# KIRKLEES METROPOLITAN COUNCIL INVESTMENT & REGENERATION SERVICE

| Reference No:         | <b>2023/62/93556/E</b>                                                                                                    |
| Site Address:         | 216, Woodlands Road, Batley, WF17 0QS                                                                                     |
| Description:          | Erection of two storey front and rear extensions and single storey side extension with balcony and associated alterations |

Rev - : DD-MM-YYYY : Initial : Issue.
Drawing Number 23-110 - P - 03

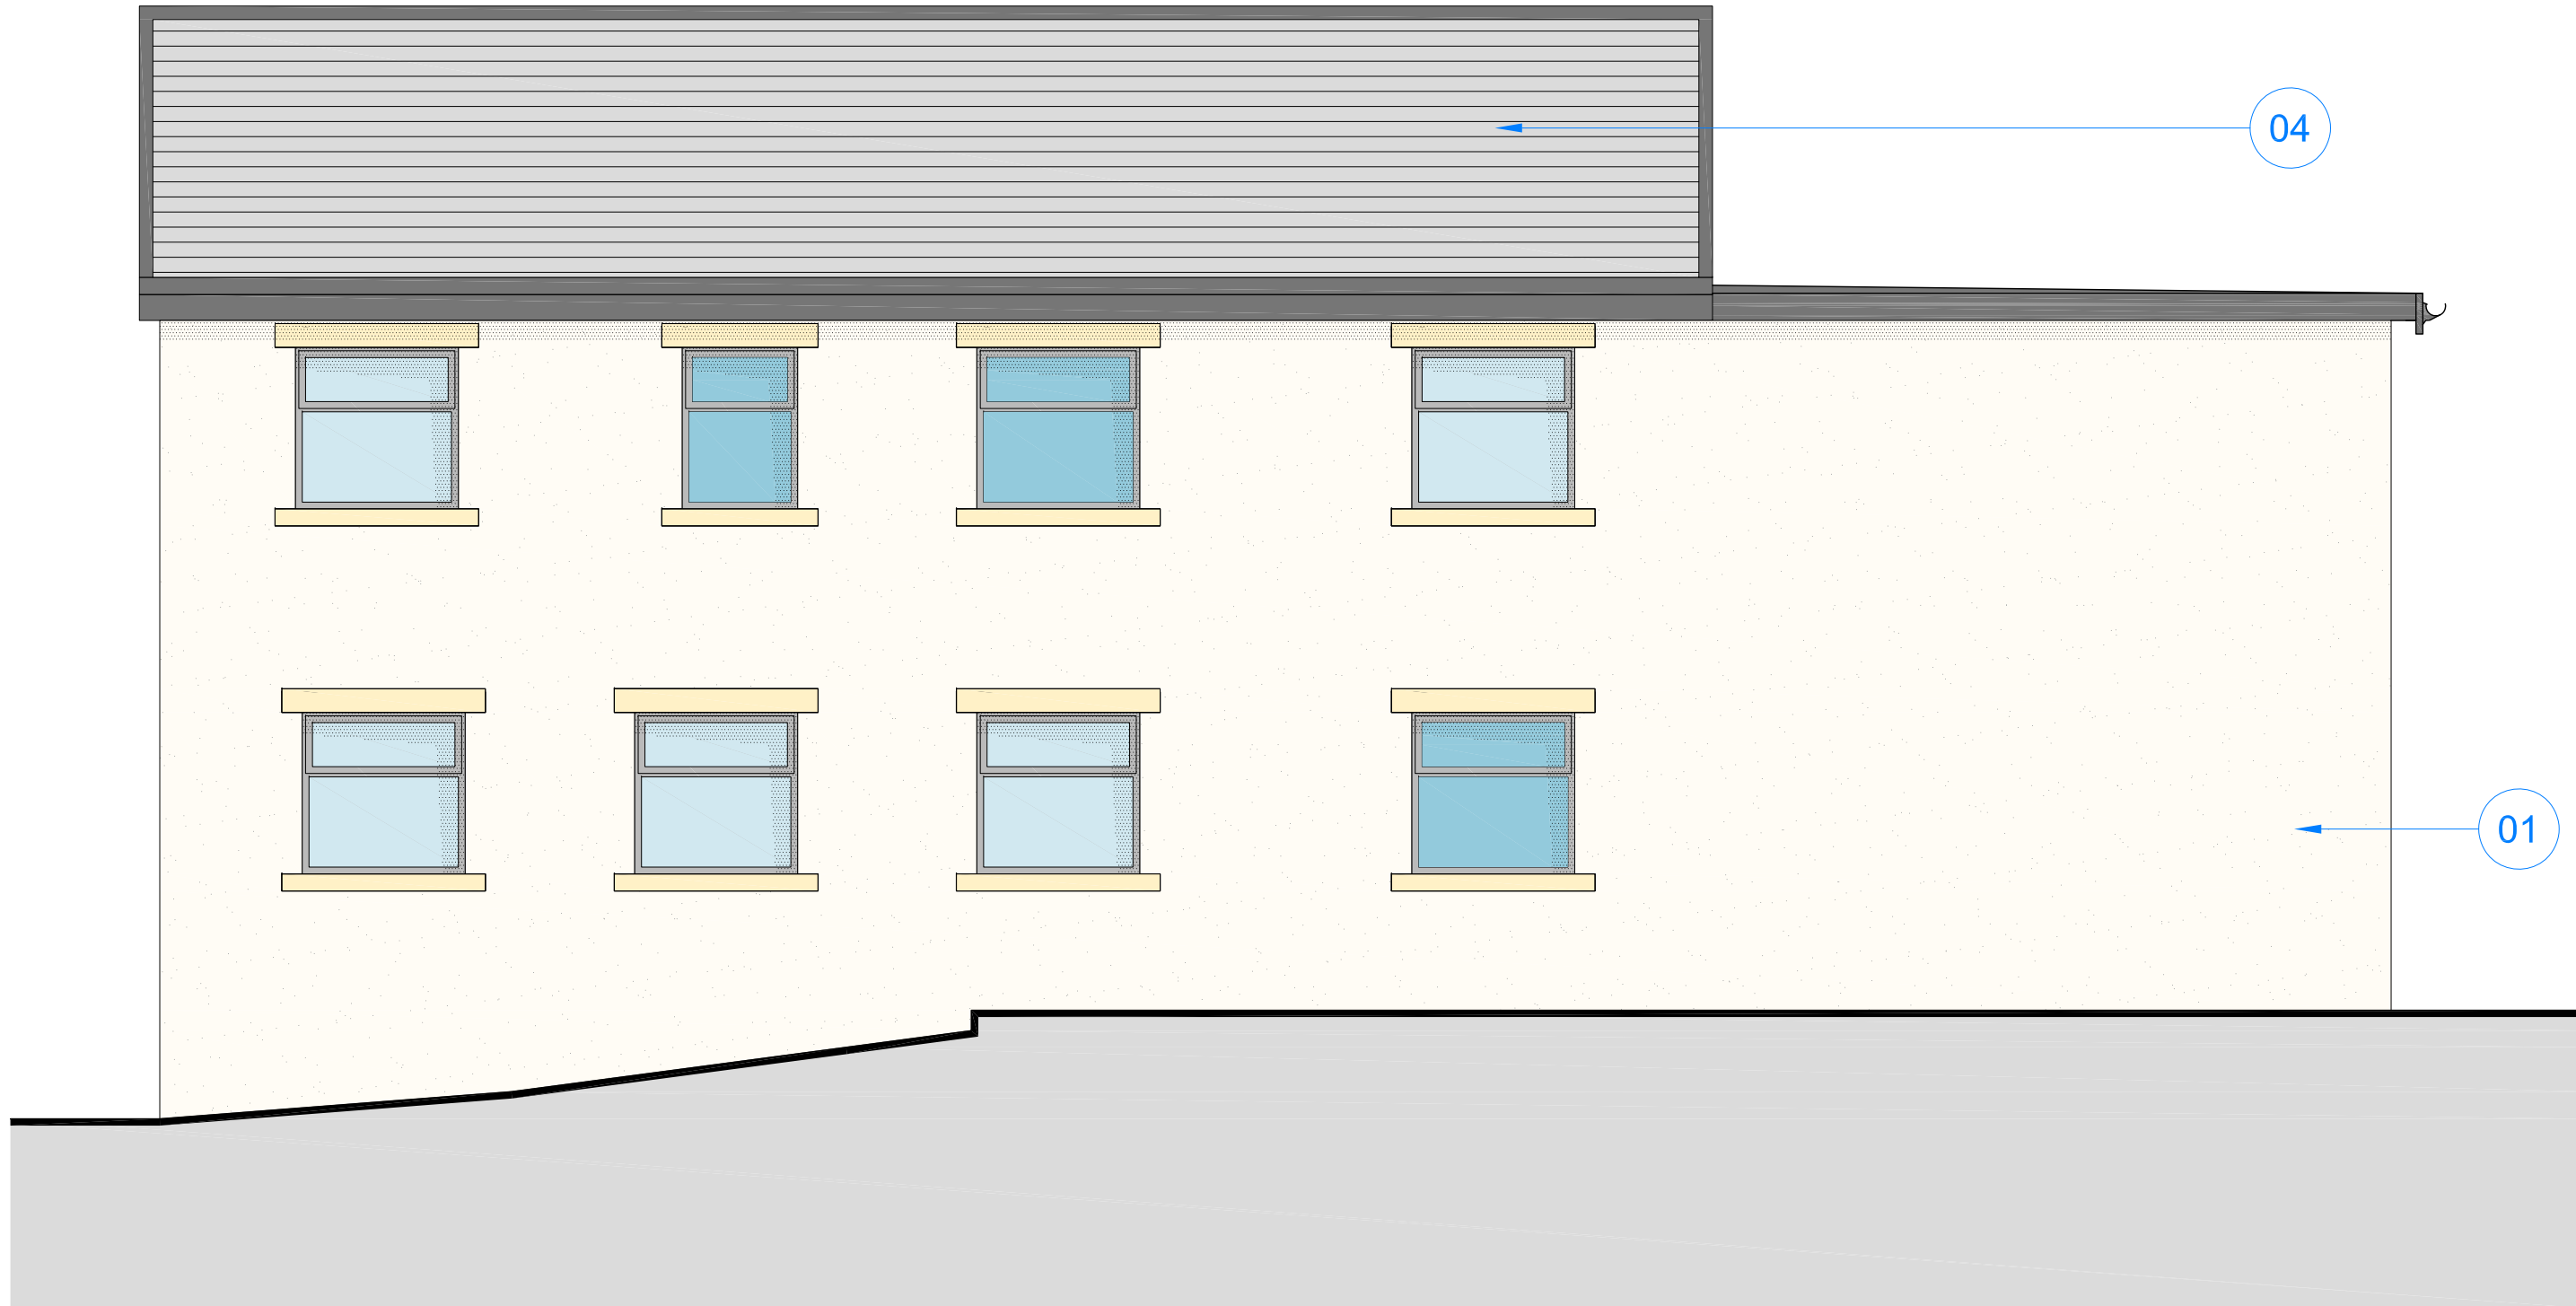
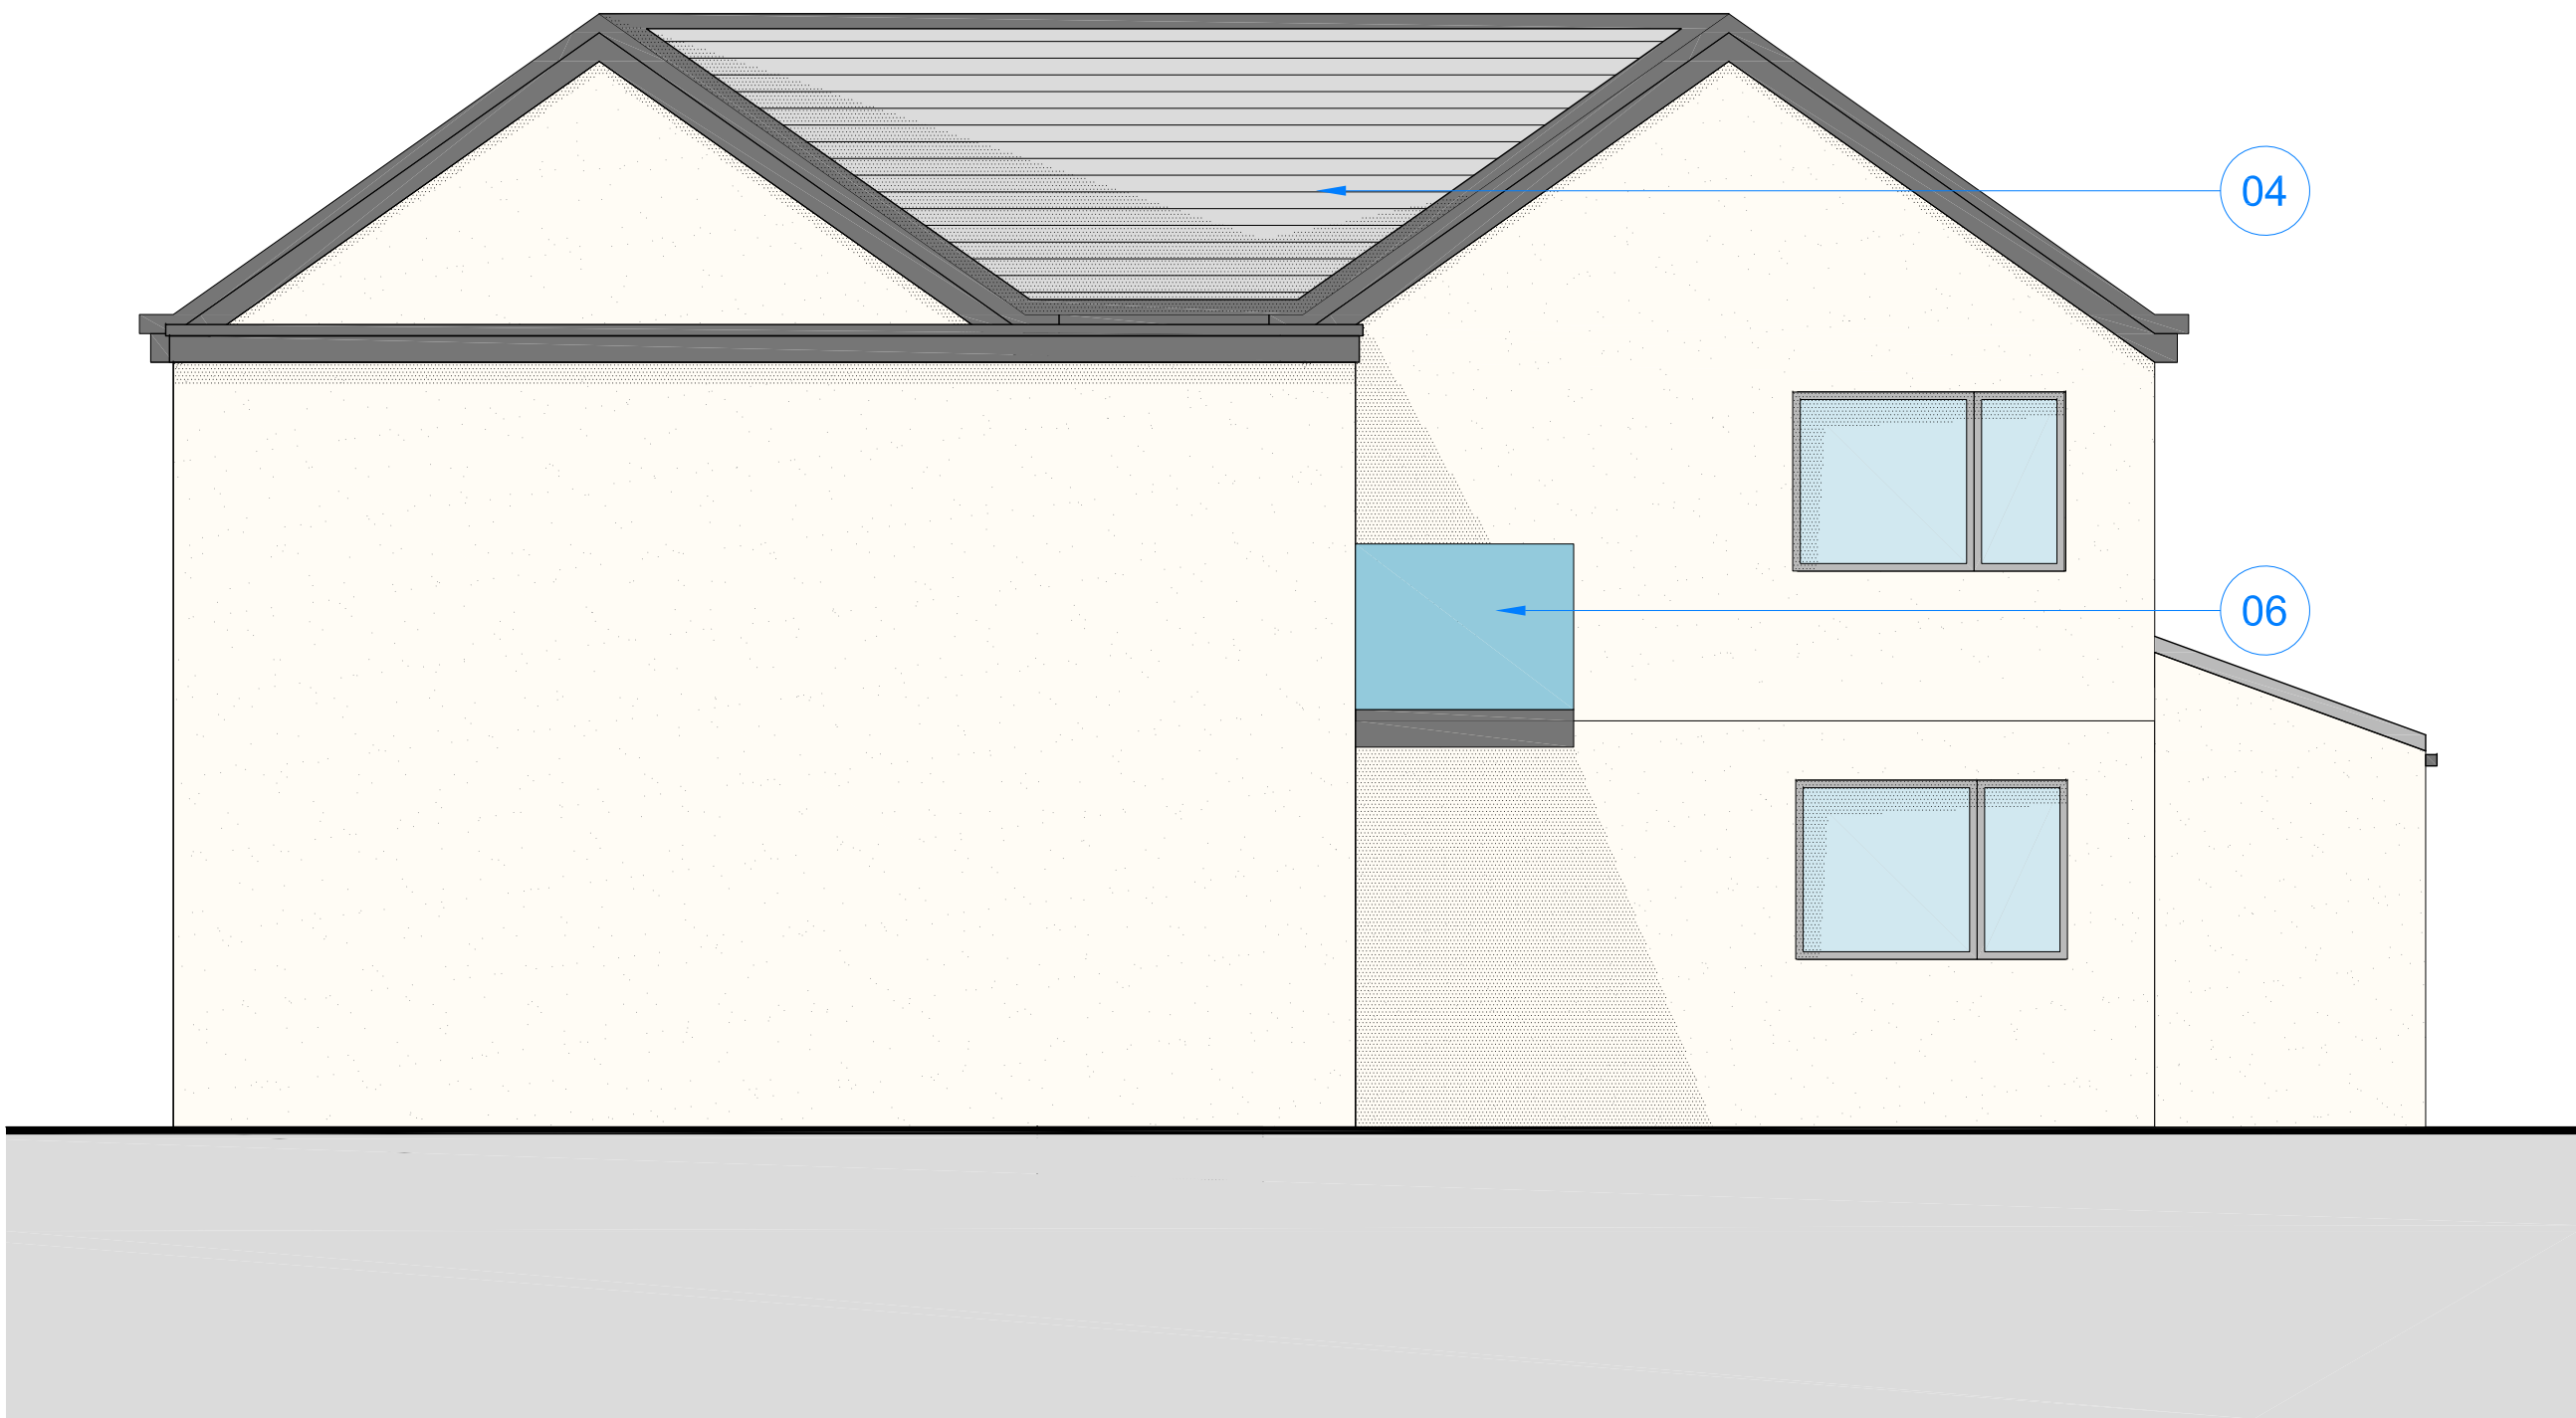
The side extension for the south east side would replace the garage and porch with a projection of 7.5m, the full depth of the dwelling with no set back or set down. The roof form would be pitched with a perpendicular link at the rear and with a flat roofed section bridging the side extension and the original house towards the front.

The two storey rear extension would project 5m from the rear of the proposed side extension with a width of 7.8m. The roof form would be flat and the plans indicate a projecting balcony on the side with a width of 1.5m and a 1m glazed balustrade at the side and rear.

The plans show the property would be rendered both over the original house and the proposed extensions.

The design of the development would not reflect the character of the host property nor the surrounding dwellings. The flat roof form proposed over the rear extension would not represent good design. The scheme consists of extensions to both sides and the rear, with inappropriate design detailing and materials which are not in keeping with the dwelling and would form an incongruous and significantly harmful relationship with the surrounding area.

The use of render would be highly out of character given the surrounding properties are predominantly brick.

There is a close relationship with the neighbouring property to the rear. Although this is off set to a degree in terms of the land levels. The rear extension would be sited at the rear of the proposed side extension which does not fully align with the dwelling to the rear. However, the rear extension would have an overbearing impact on the amenity space of the neighbour. Furthermore, the balcony proposed would result in overlooking into the neighbours amenity space and ground floor windows on their rear elevation.

Rev - : yyyy-mm-dd : Initial : Revision Notes
Drawing Number 23-110- P - 02

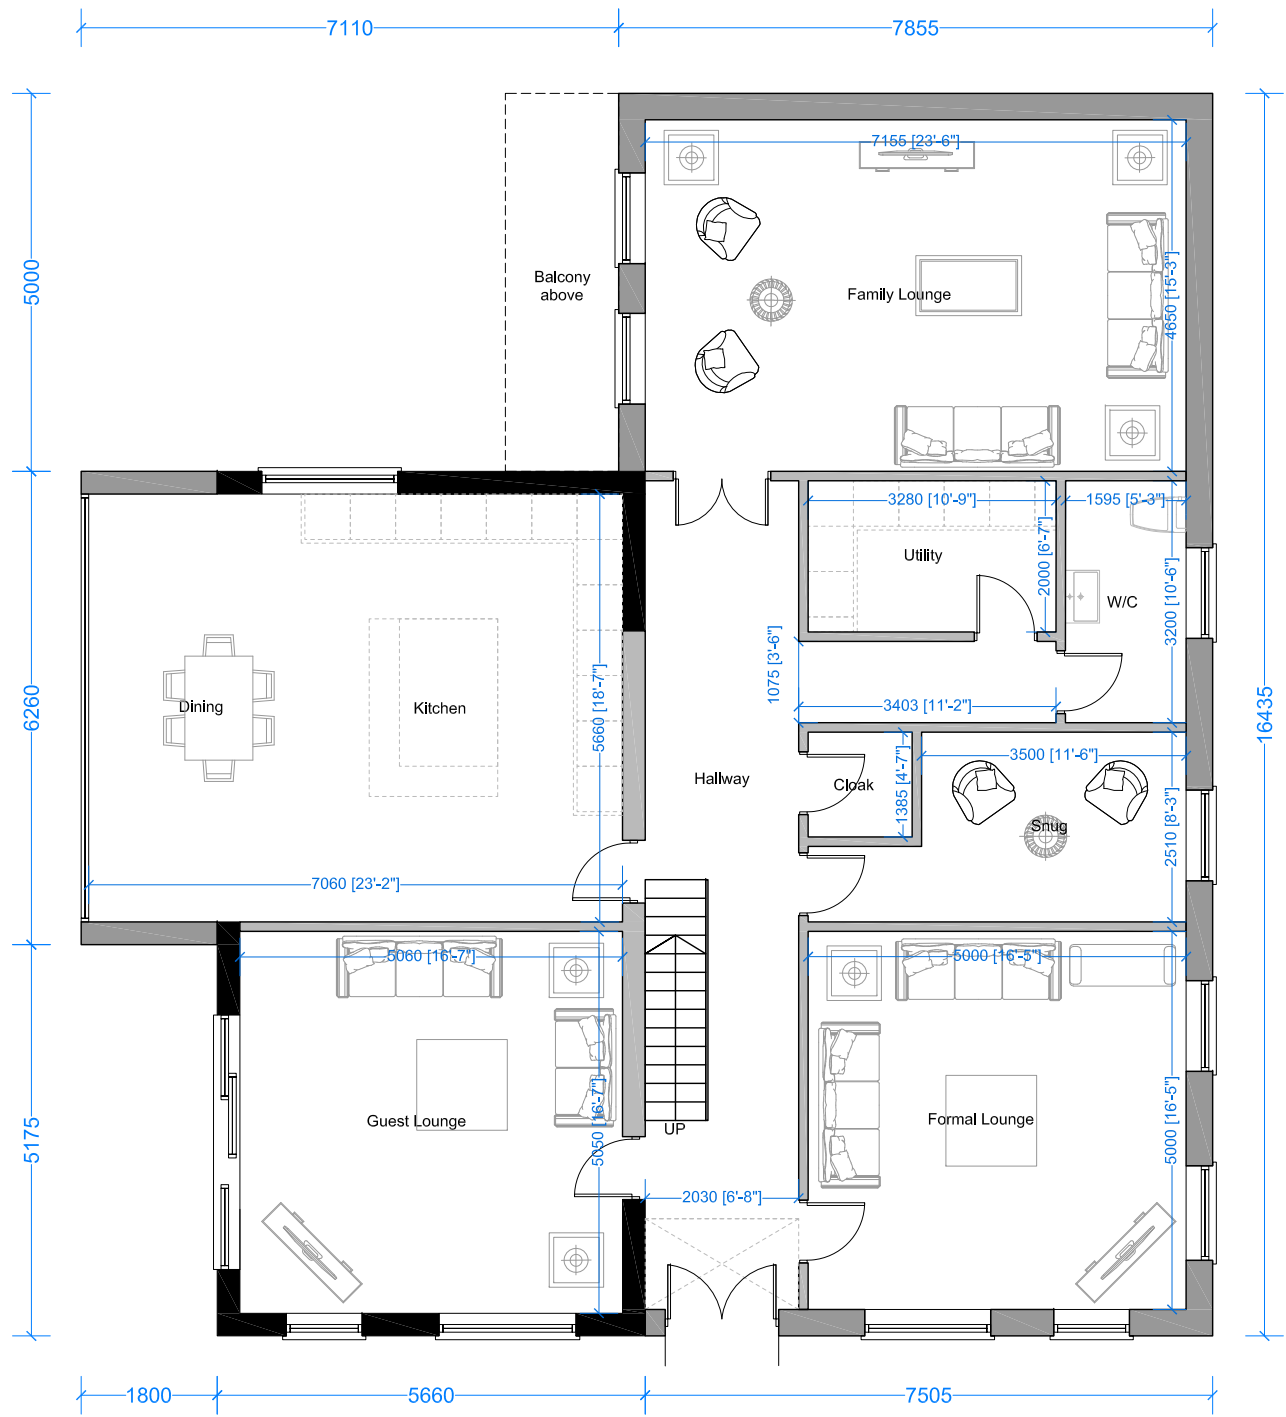
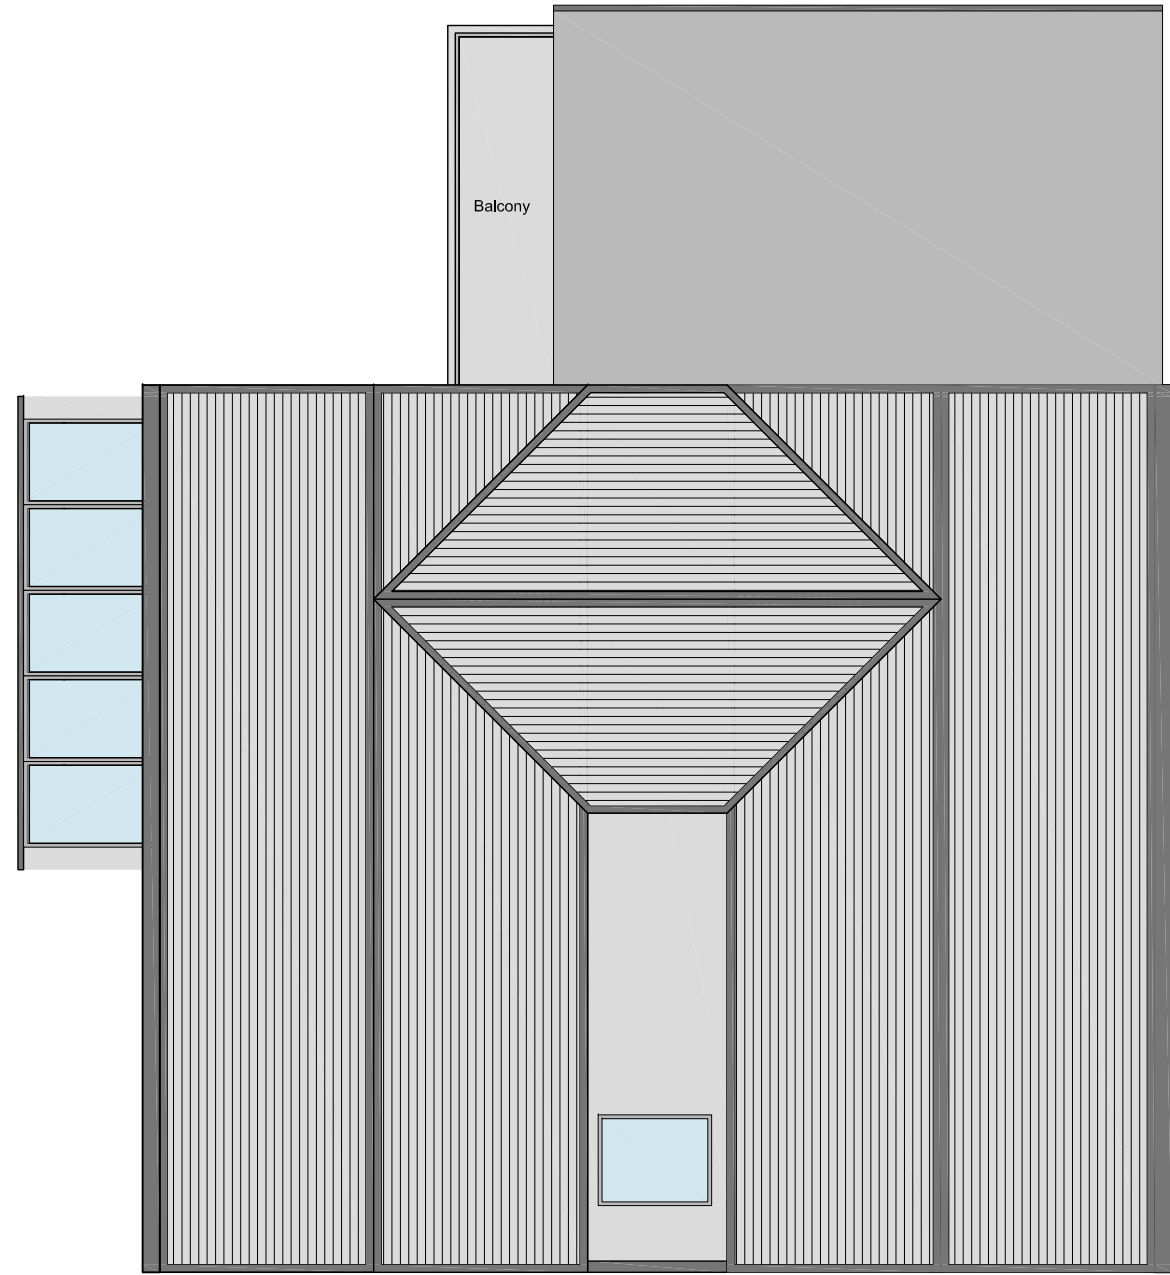
The plans show a single storey side extension on the north west side which would be set back 5.1m from the front, projecting 1.8m with a depth of 6.3m. The roof form would be a lean to glazed roof.

The scale of the extensions proposed to the sides and rear of this property are significant and would not form subservient additions to the property. In particular, the side extension on the south side is more than the width of the original house and the rear extension would cover all of the very limited land at the rear of the dwelling. The scale is therefore not considered to be acceptable.
